DECISION DELEGATED TO HEAD OF PLANNING

Application No: H21-0983-25 **Applicant:** Mr D Withers

Proposal: Erection of single-storey rear and side extensions - Approved under H21-0859-24. Modification of Condition 2 to allow amendments to previously approved plans

Location: The Copse Church Way Tydd St Mary

Proposed Elevations 1:100

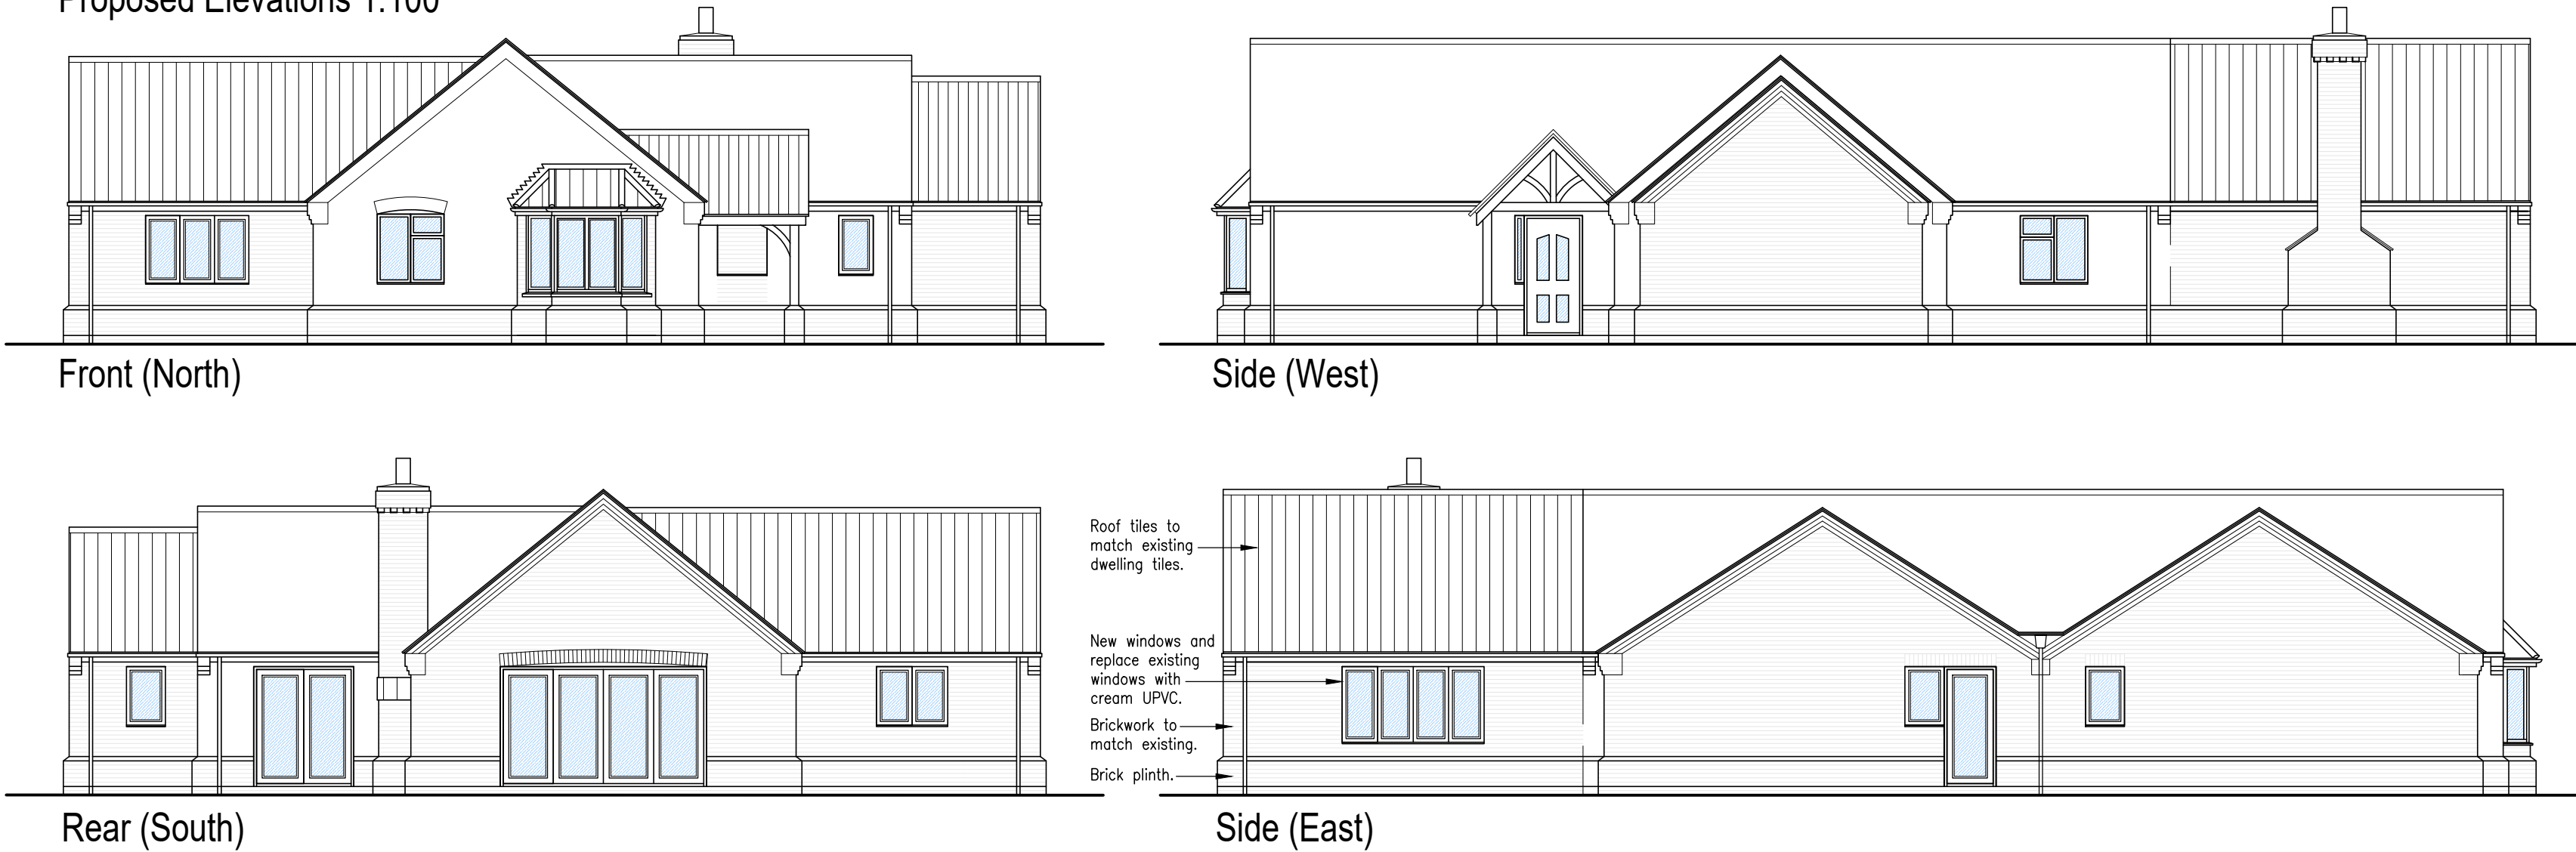
As outlined above, the only change within this application is to include a chimney on the side elevation. This proposed chimney would be approximately 350mm less than an existing chimney on site; albeit, the design of the chimney is notably different and the previously permitted scheme, sought to remove the existing chimney.

Given the modest scale, appropriate design and its location on the side elevation which would ensure the addition is less visible and prominent along the street scene, the proposal would not cause an unacceptable impact upon the character or appearance of the area.

As this application is purely for the addition of a chimney for a fireplace, there would be no harm in relation to overlooking. Furthermore, due to the fairly minor scale of the chimney there would also be no material overshadowing concerns either.
